**Application by RWE Renewables UK Solar and Storage Limited for an Order granting Development Consent for the Tween Bridge Solar Farm
Responses by National Highways Limited to the Examining Authority's First Written Questions**

Sheet 10 of 12

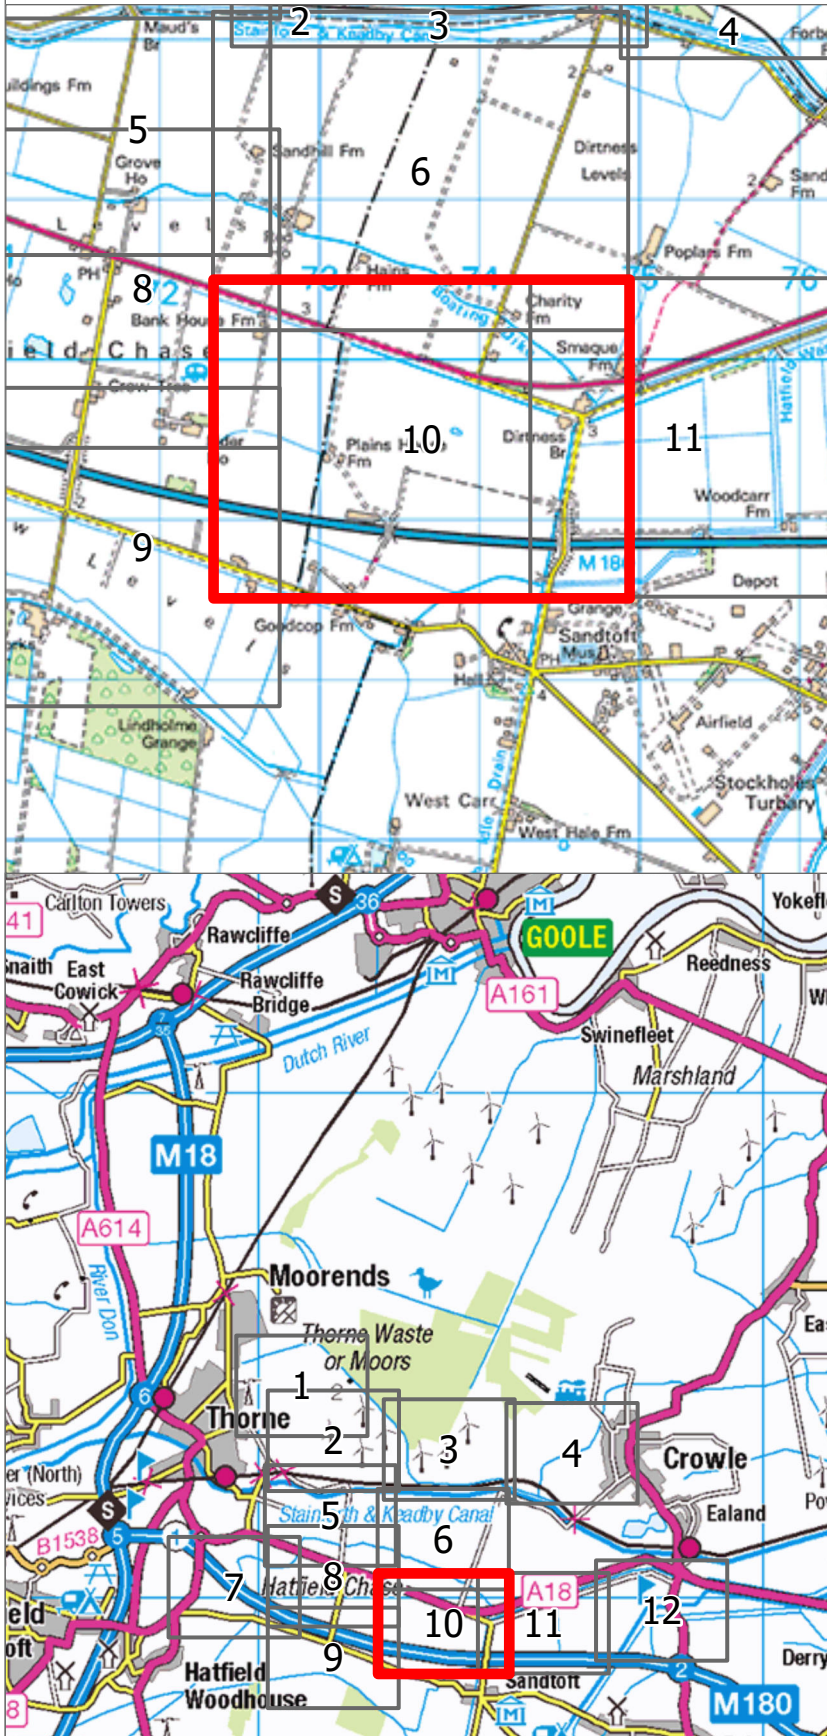
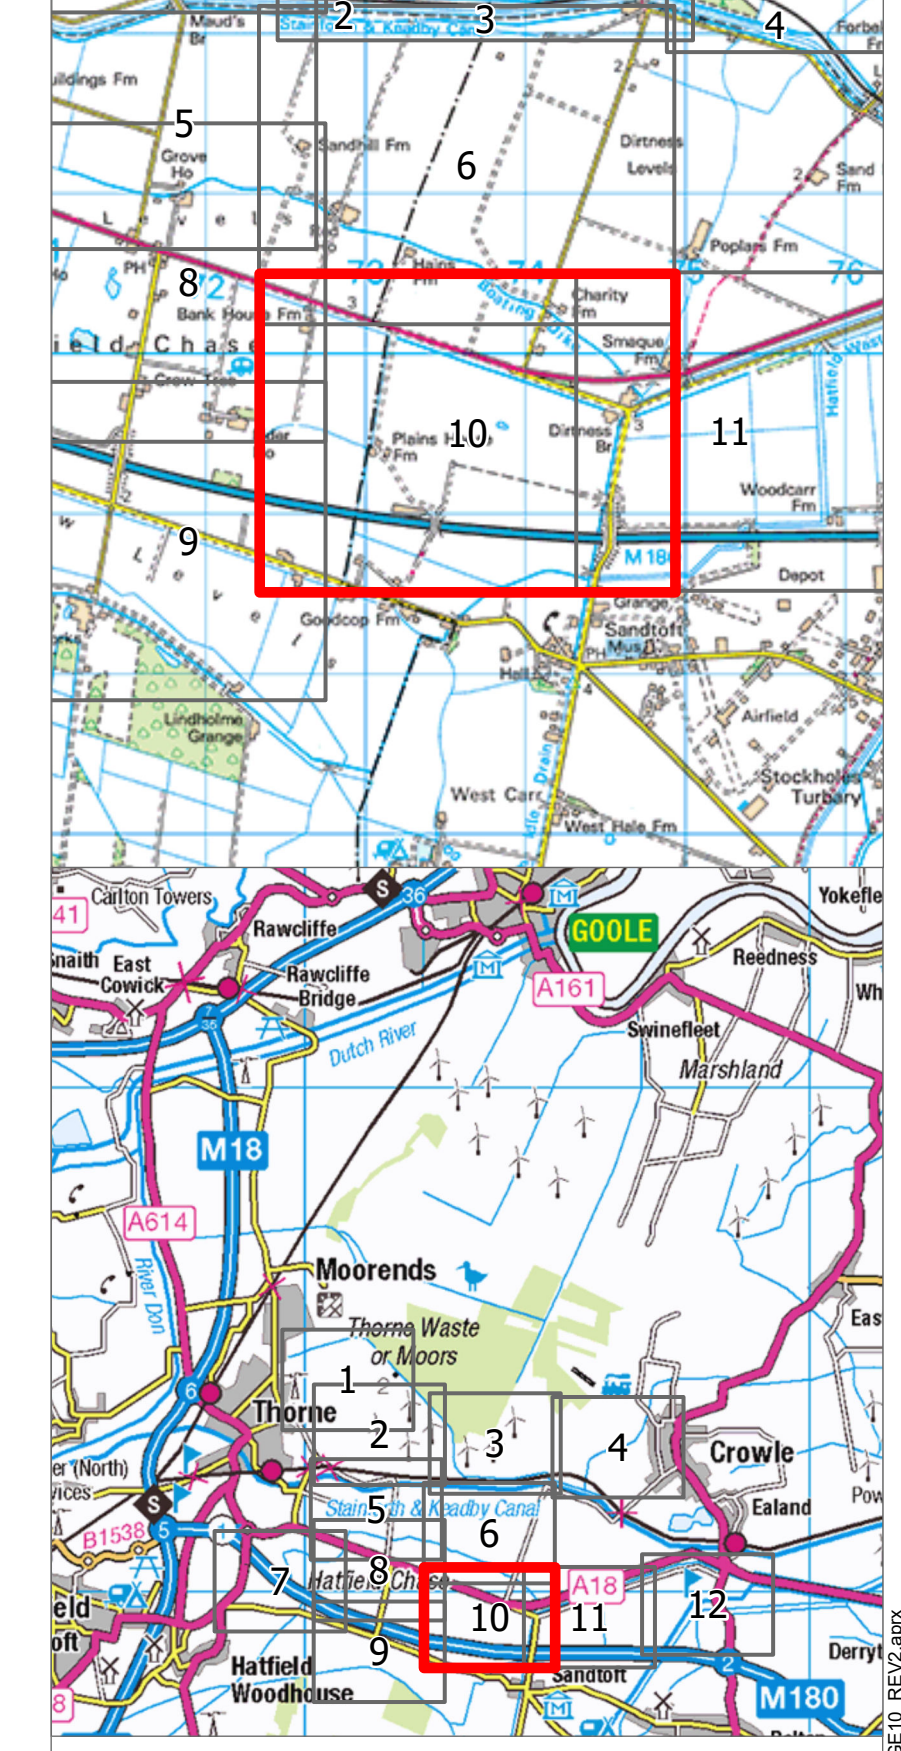
ExQ1	Question to:	Question:	NH response:
<p>Q4.0.9</p>	<p>All affected persons</p>	<p>Accuracy of the Book of Reference, Land Plans and Points of Clarification</p> <p>APs are asked to please provide comments on the following:</p> <p>a) If they are aware of any inaccuracies in the BoR [APP-021], the Statement of Reasons [APP-019] or the Land Plans [APP-008]. If so, please indicate where these are and provide the correct details.</p> <p>b) Views on whether there may be any reasonable alternatives to CA or Temporary Possession (TP) sought by the applicant.</p> <p>c) Views on whether there are any areas of land or rights that the applicant is seeking the power to acquire that you consider are not needed.</p> <p>d) Details of any other concerns relating to the legitimacy, proportionality or necessity of the CA or TP powers sought by the applicant that would affect the land that you own or have an interest in.</p>	<p>a) NH notes that the Book of Reference [REP1-008] has been updated by the Applicant at Deadline 1 to correct the instances of a typographical error in NH's name, and to remove reference to NH having an interest in plot 7/14.</p> <p>As noted in its Written Representation [REP1-067], NH also requests that it is removed from the Book of Reference in respect of plots 10/12 and 10/15, on the basis that these plots have been vested in the local highway authority.</p> <p>b) NH has no comment in respect of this limb.</p> <p>c) NH has no comment in respect of this limb.</p> <p>d) As outlined in its Written Representation [REP1-067], to safeguard NH's interests and the safety and integrity of the SRN, NH objects to powers of compulsory acquisition being granted in respect of NH's operational land, and to any extinguishment of rights enjoyed by NH for the purposes of carrying on its undertaking. The relevant plots constitute land or rights acquired / obtained by NH for the purpose of maintaining its statutory undertaking. NH considers that there is no compelling case in the public interest for the exercise of compulsory acquisition powers over these plots without the inclusion of satisfactory protective provisions for the benefit of NH on the face of the DCO. The protective provisions for the benefit of NH currently presented in the draft DCO [REP1-004] represent a much-reduced standard of protection than that which NH expects with respect to a development of this nature, which has the potential for substantial impacts on the SRN.</p> <p>In particular, three of the plots over which powers of compulsory acquisition are sought (9/24, 10/21 and 11/25) comprise land forming part of the SRN. In all three cases, powers are sought to lay electrical cables (Work No. 2). The Applicant has indicated to NH that cabling works are not proposed in respect of all three plots, in which case it is unclear why such powers are</p>

<p>currently sought in respect of those plots. NH notes that cabling works are shown on Sheet 10 of the Street Works, Access and Public Rights of Way Plan in respect of plots 9/24 and 10/21 [REP1-003].</p> <p>In respect of plot 11/25, the Book of Reference [REP1-008] describes this plot as “3860 square metres of highway drain”. NH raised concerns in its Written Representation [REP1-067] regarding the Applicant’s possible reliance on highway drainage apparatus for outfall from the Proposed Development, which is not permissible and would be contrary to Government policy.¹ The Applicant has since advised that it does not anticipate any proposals to outfall surface water runoff into highway drainage apparatus, but NH would reiterate that any such proposals are not legitimate and requests further explanation from the Applicant as to why this plot is required for the Proposed Development.</p>

<p>Q4.0.12</p>	<p>Statutory Undertakers</p>	<p>Protective Provisions</p> <p>Please set out your position with regards to the tests under s127 and s138 of PA2008 as applicable to your respective interests.</p>	<p><u>Section 127</u></p> <p>As set out in respect of Q4.0.9 above, plots 9/24, 10/21 and 11/25 comprise land forming part of the SRN. NH therefore holds an interest in these plots for the purposes of carrying on its undertaking, and section 127 of the Planning Act 2008 is engaged.</p> <p>As noted above, in all cases, powers are sought to lay electrical cabling in these plots (Work No. 2). In respect of plots 10/21 and 11/25, powers are additionally sought to undertake facilitatory works including highway works (Work No. 8). Plot 10/21 comprises an embankment supporting a bridge on which the local highway network overpasses the SRN. As explained in NH’s Written Representation [REP1-067], any works proposed beneath or above the SRN constitute a potential operational and safety risk, and therefore risk serious detriment to NH’s undertaking. It is not possible for this risk to be avoided through replacement land, as no land can replace the existing structure of the SRN – it cannot be re-provided or relocated elsewhere. As such NH does not consider that the test set out in section 127 can be satisfied in respect of these plots.</p> <p><u>Section 138</u></p>
